Botley West Solar Farm Ref: EN010147 - Deadline 1: June 4th 2025
For the attention of the Planning Inspectorate. Our reference number: RR 0413

Botley West Solar Farm: Written Representations, absorbing information from earlier submissions, accompanying ICOMOS-UK's Registration as an Interested Party, including a Summary and overlays on the Applicant's 'Botley West Solar Farm Preliminary Masterplans'.

These comments and Masterplan overlays are from the Cultural Landscapes and Historic Gardens Committee of ICOMOS-UK.

Project: AG1803	Sheet: Field 2.112
Date: November 2024	
Scale: 1 : 4000 @A3

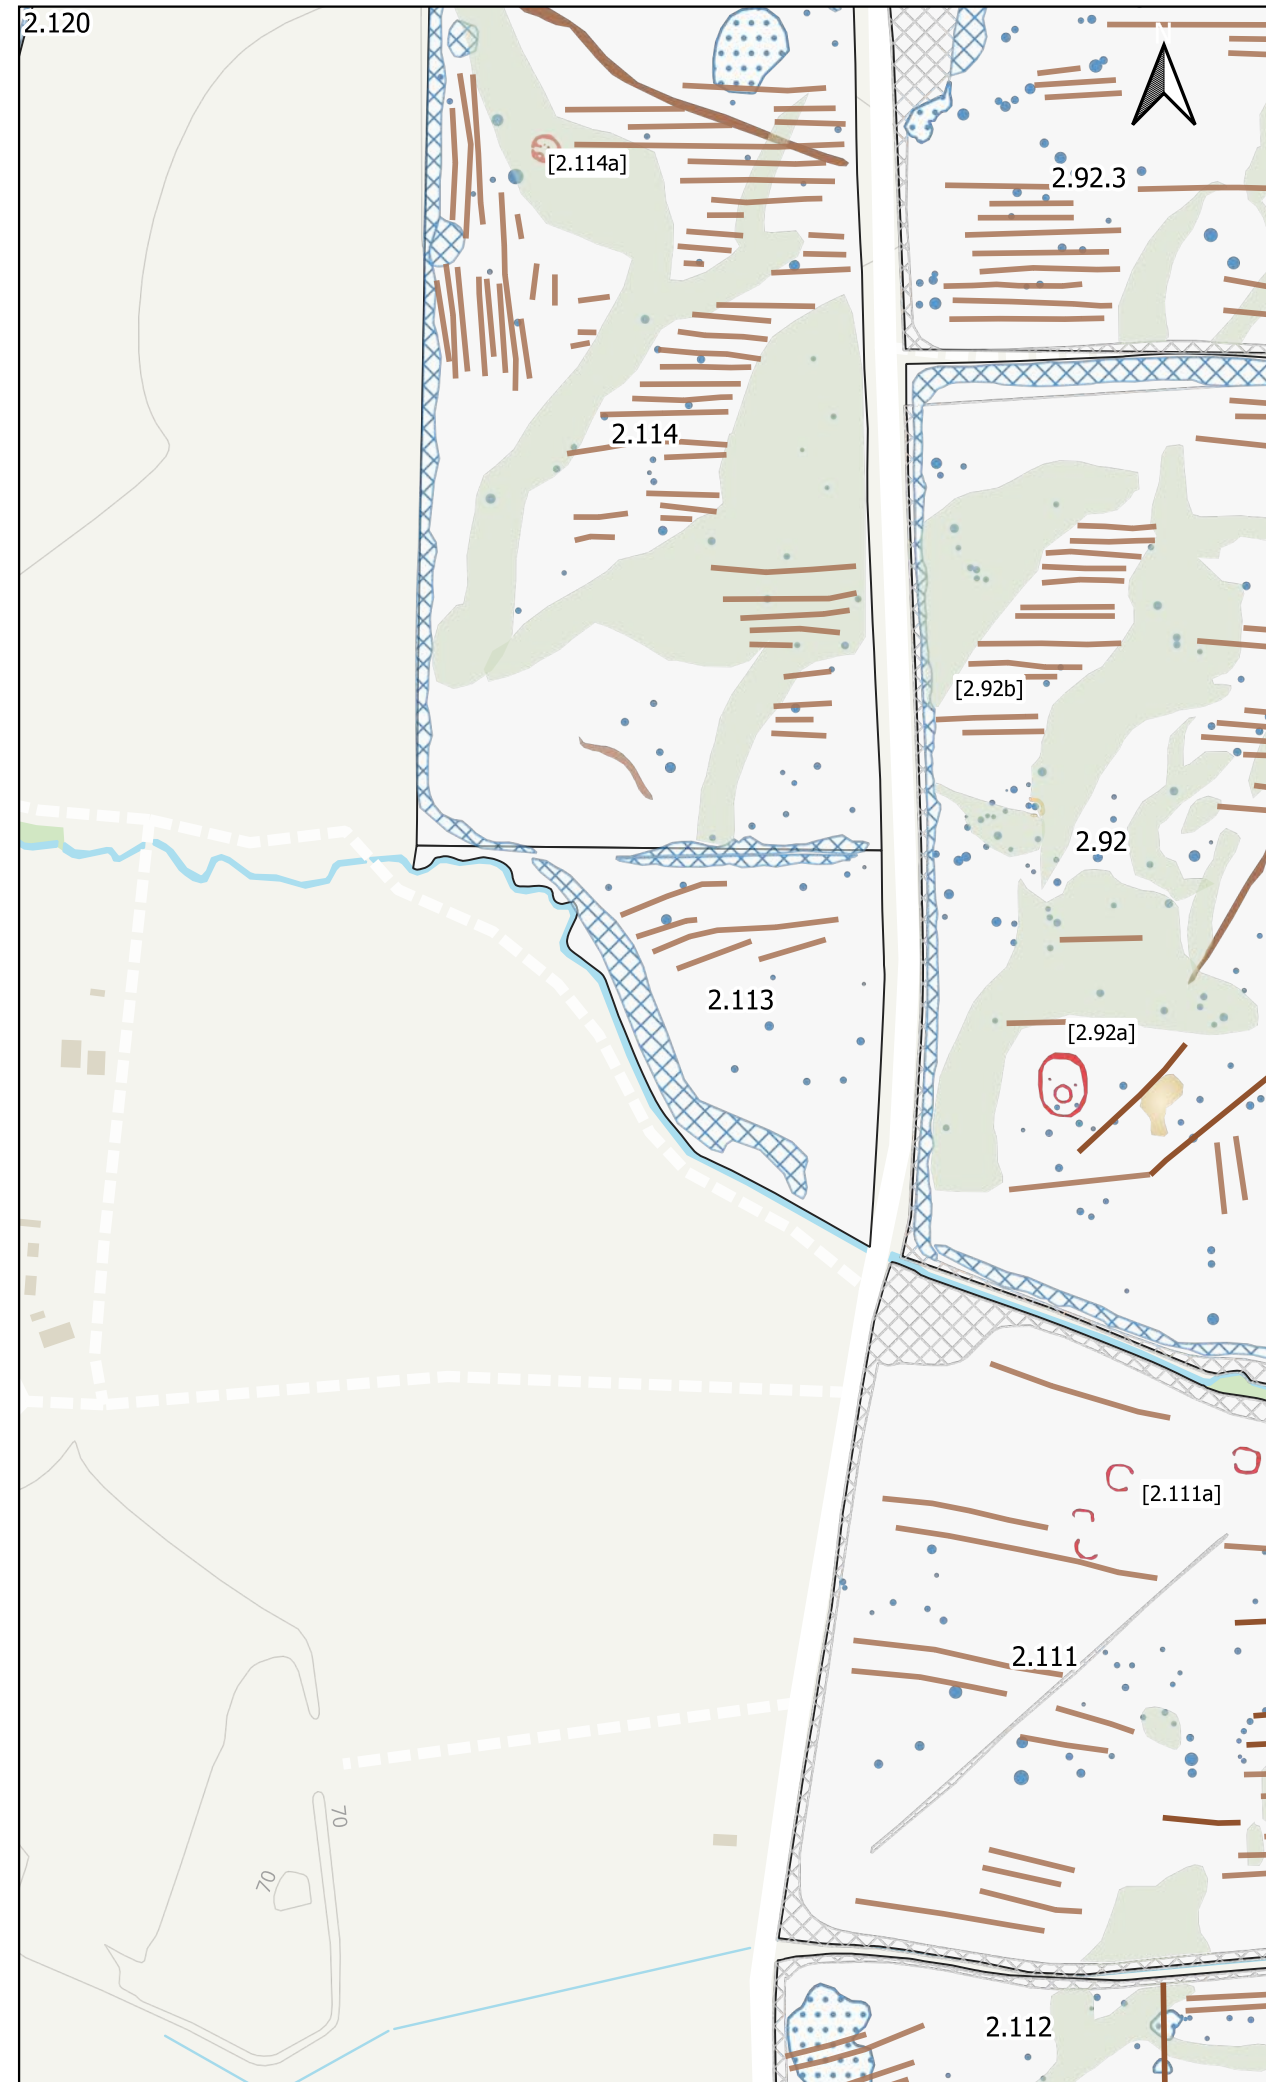
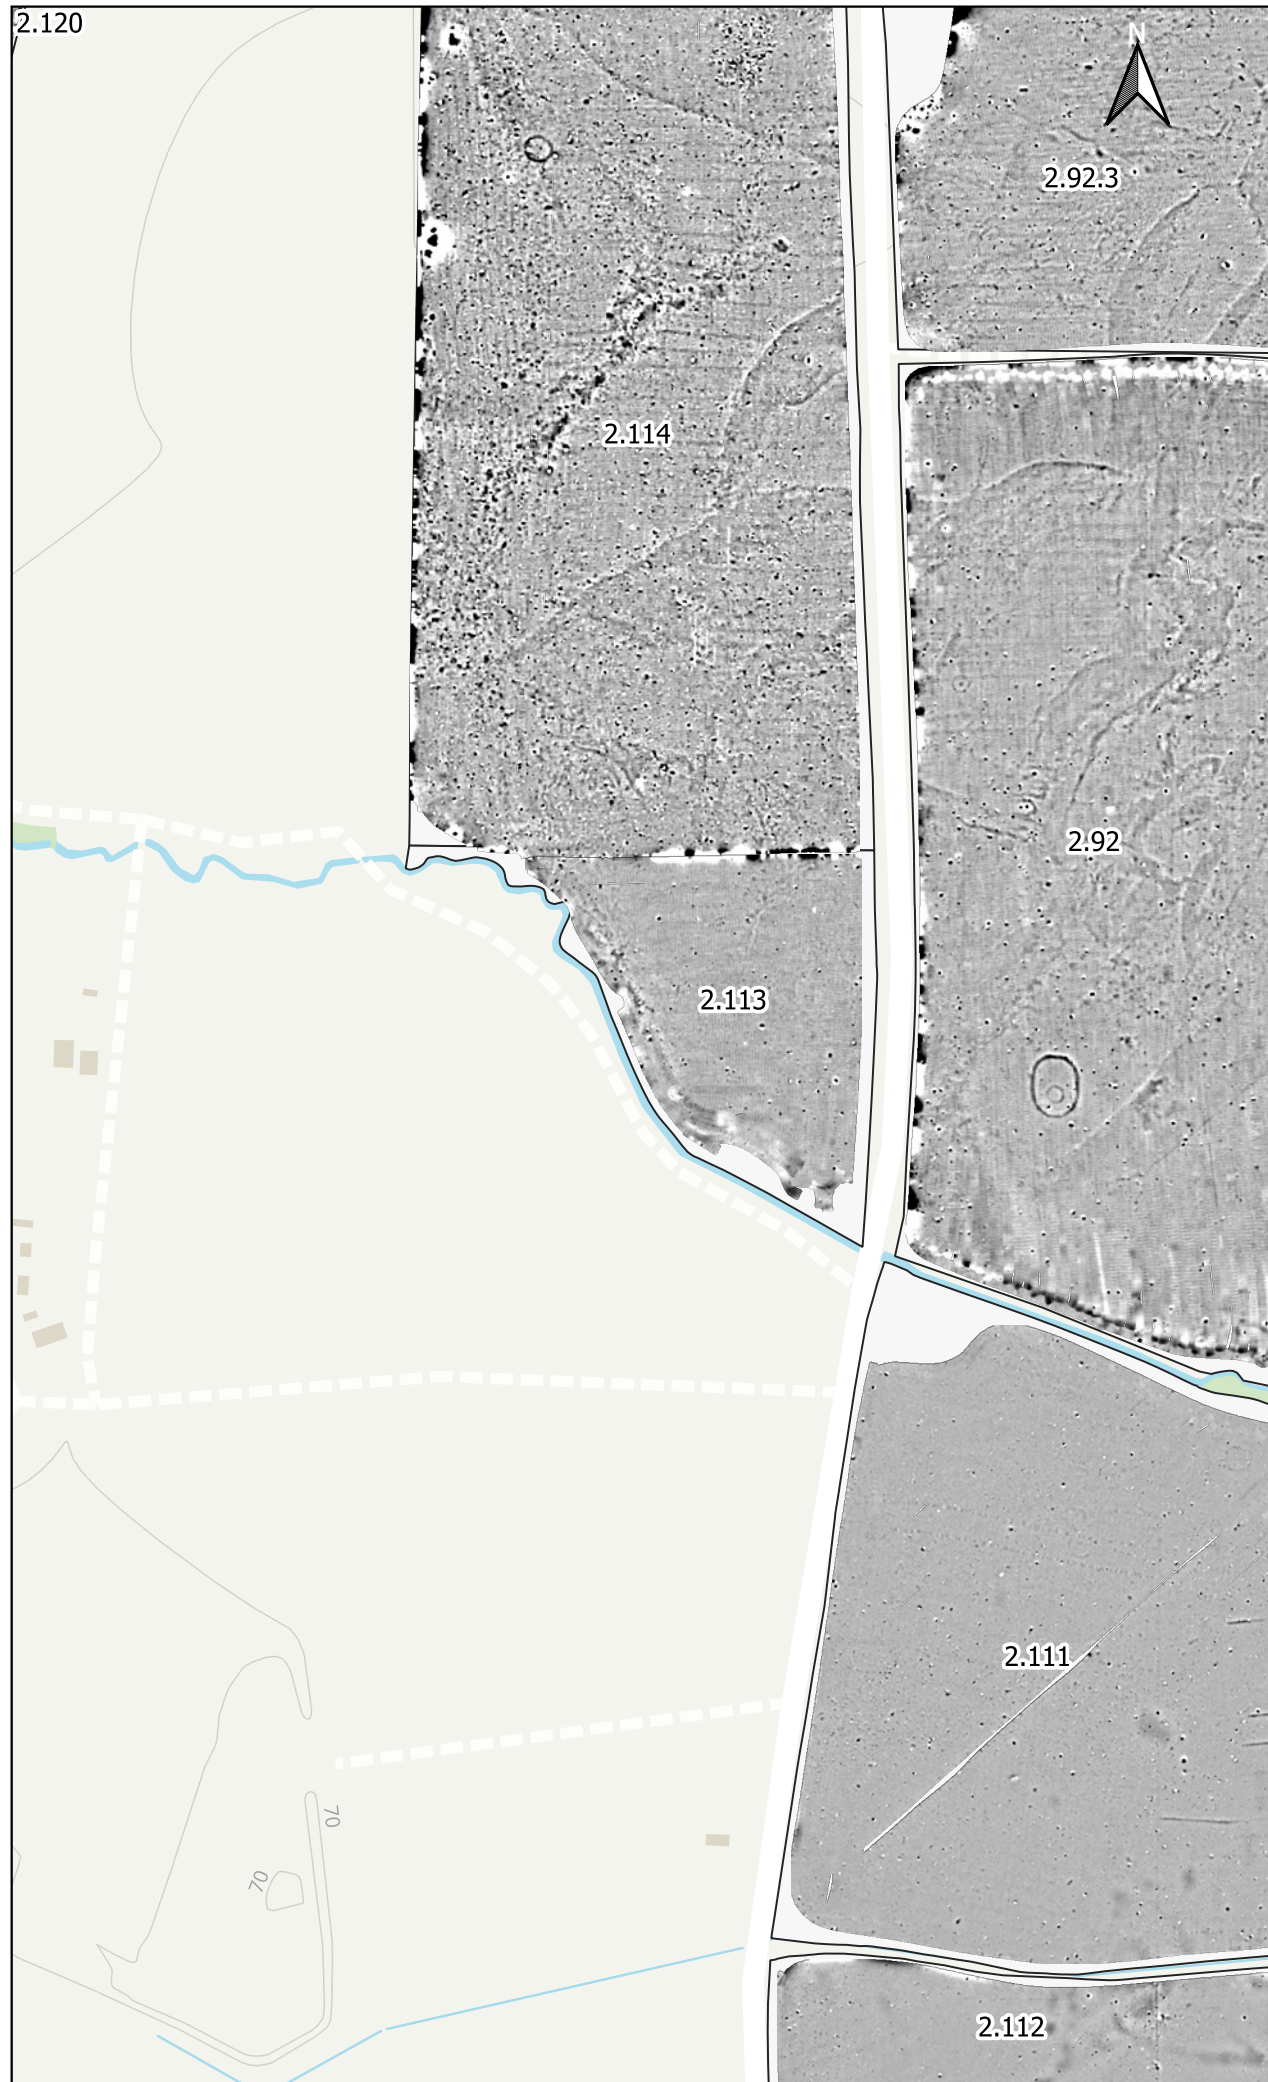
No attention has been paid to the conservation of the important north-easterly views identified on the Salt Cross Garden Village spatial framework as *panoramic views*. Salt Cross is a new village to be built beside the Oxford green belt west of Oxford. To conserve these panoramic views across the Evenlode valley to the escarpment on its north-eastern flank, **all the fields near the north-east of Salt Cross should be excluded from consideration for solar farm development [2.97; 2.92; 2.111; 2.112; 2.113; 2.114]** (as indicated on Masterplan-Middle Section 3).

Project: AG1803	Sheet: Field 2.115
Date: November 2024	
Scale: 1 : 5000 @A3

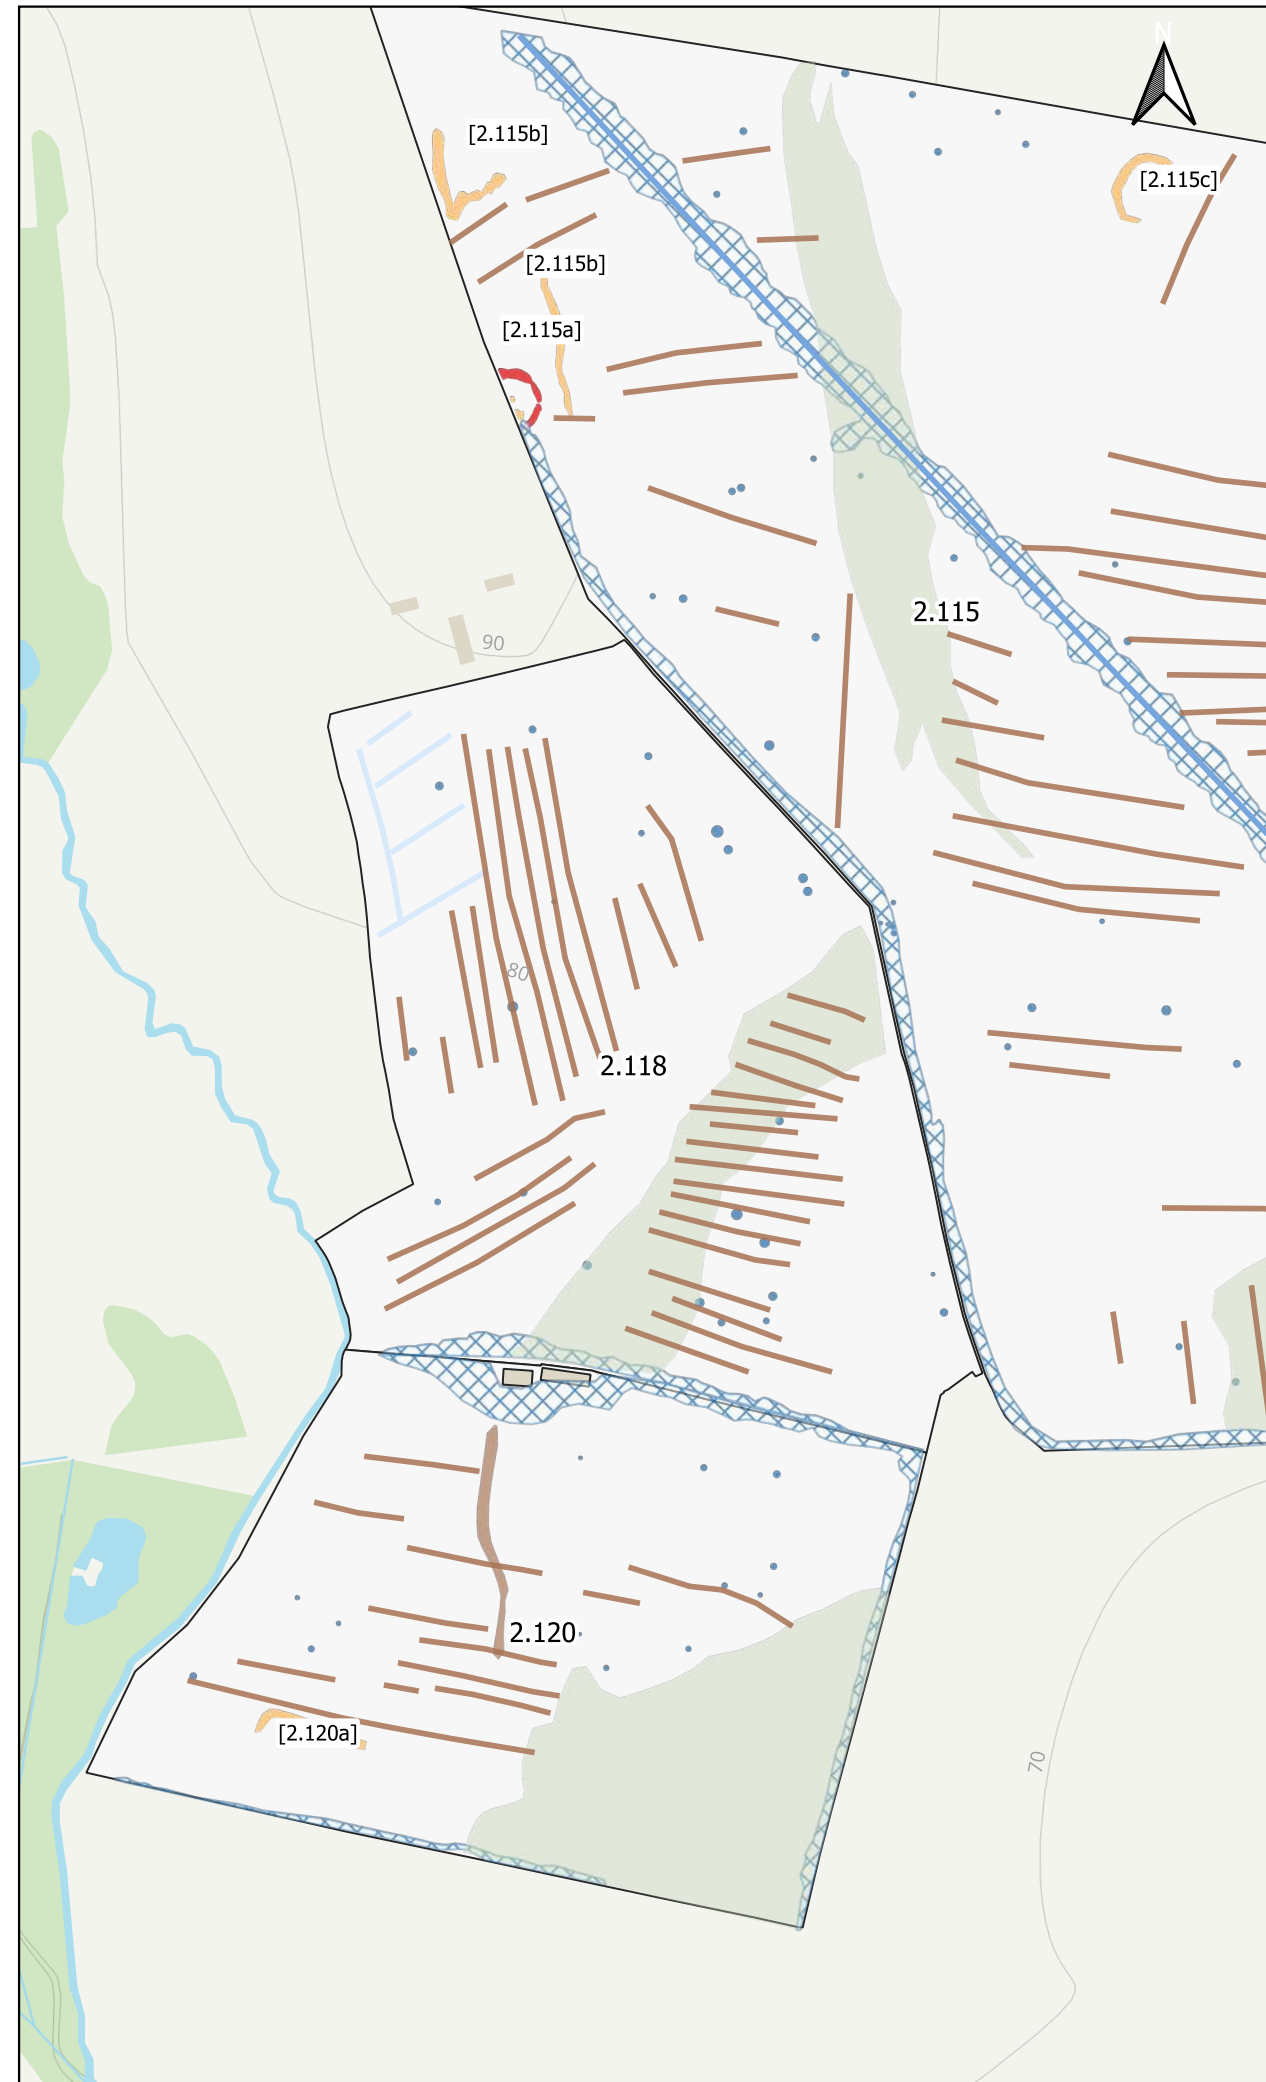
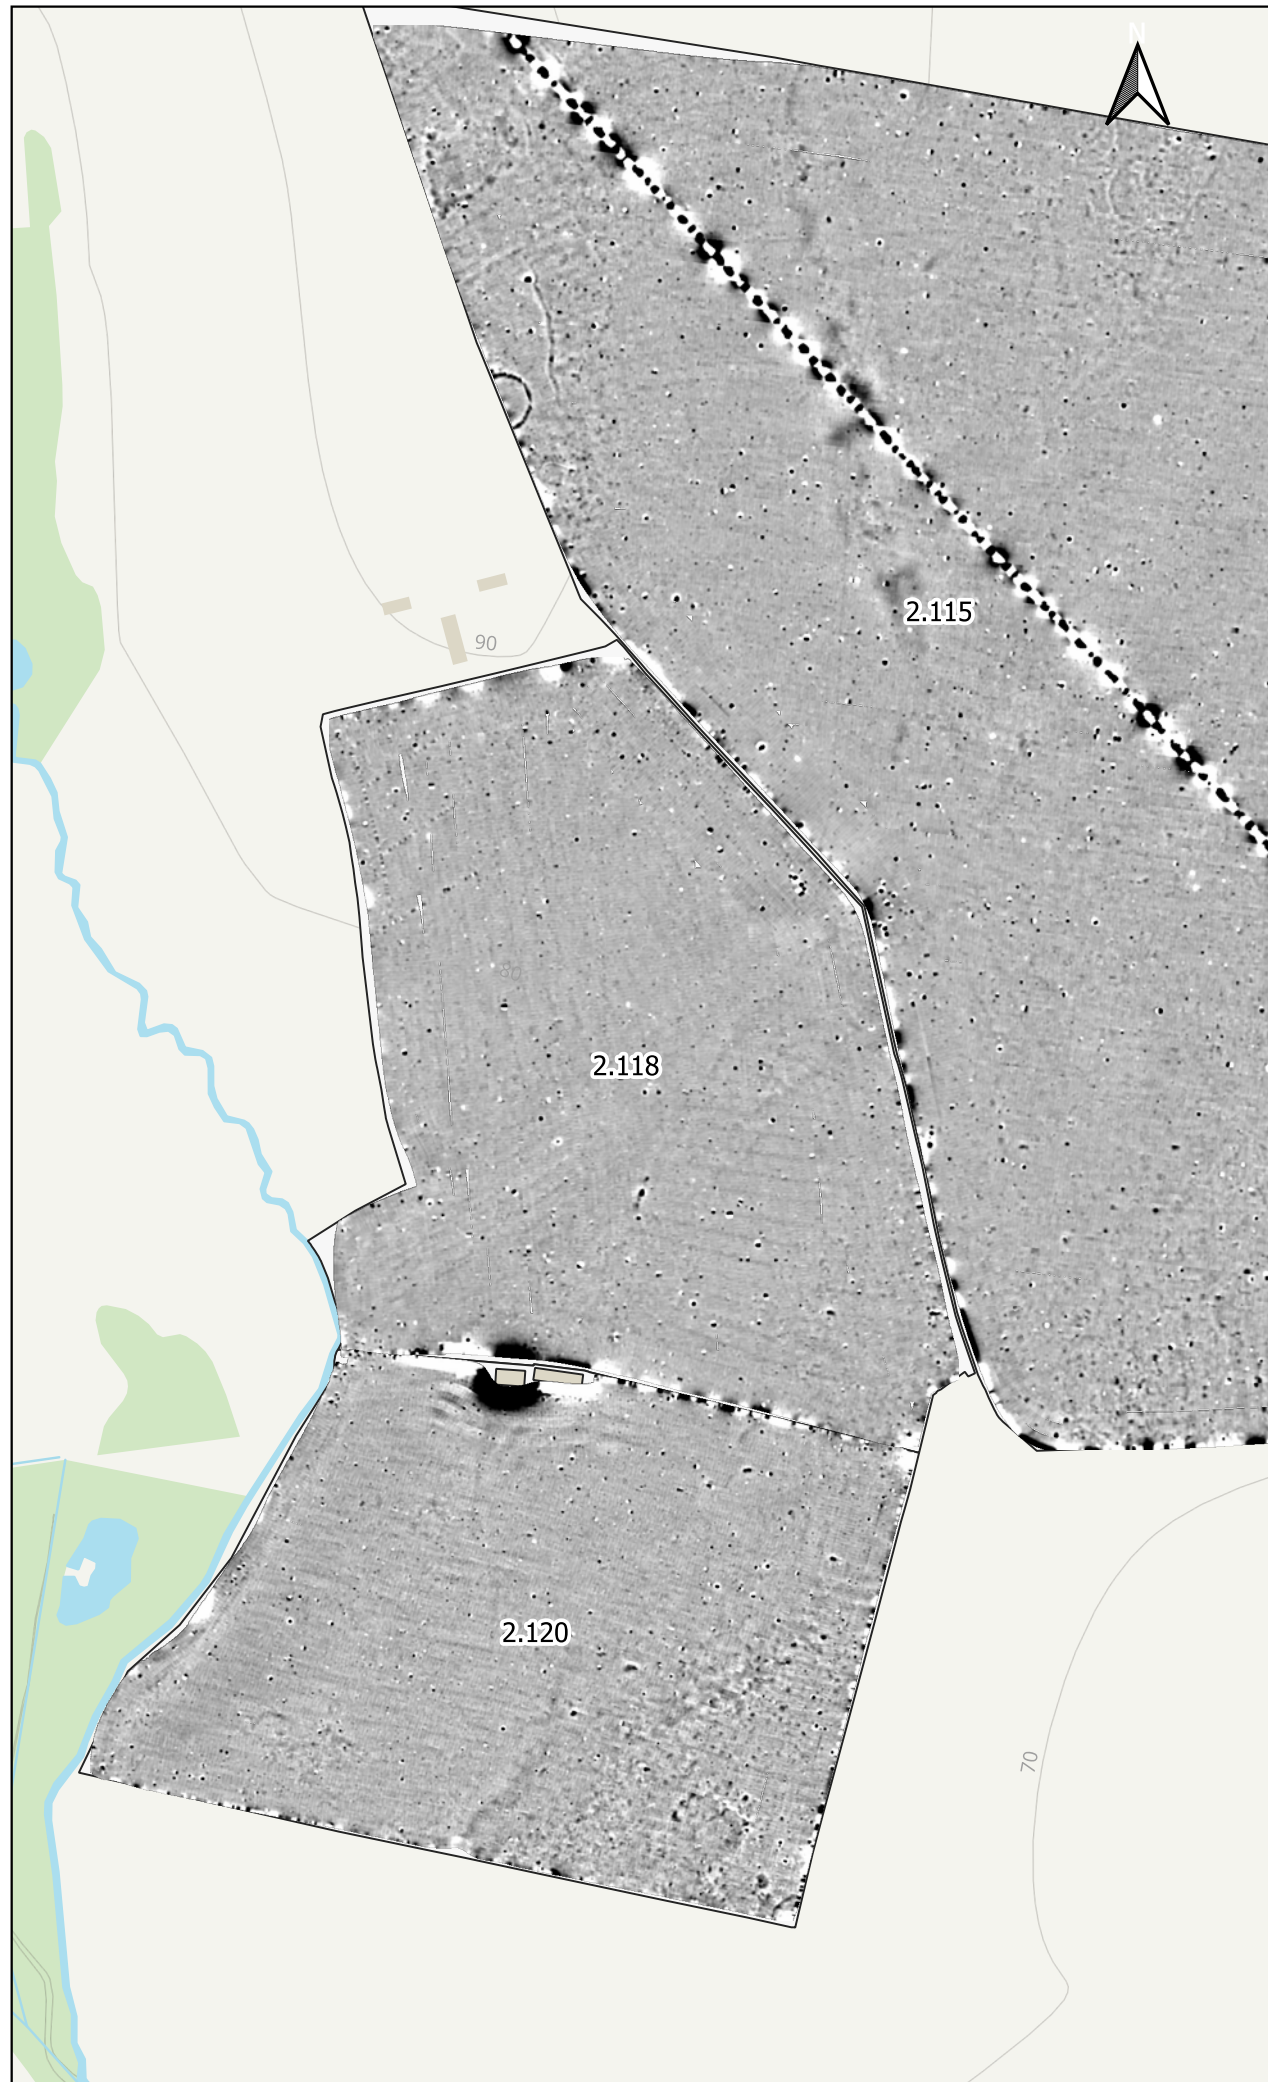
Church Hanborough's soaring limestone steeple can be seen across fields from every point of the compass (England's 1000 Best Churches by Simon Jenkins). To conserve most of these views and the setting of the village, in particular the rural scenery of the valley passing the western side of the village, **no solar arrays should be placed on the sloping sides of the ridge to the south of Chuch Hanborough village [2.115 NW arm; 2.118; 2.119; 2.120]** (as indicated on the west side of Masterplan-Middle Section 3).
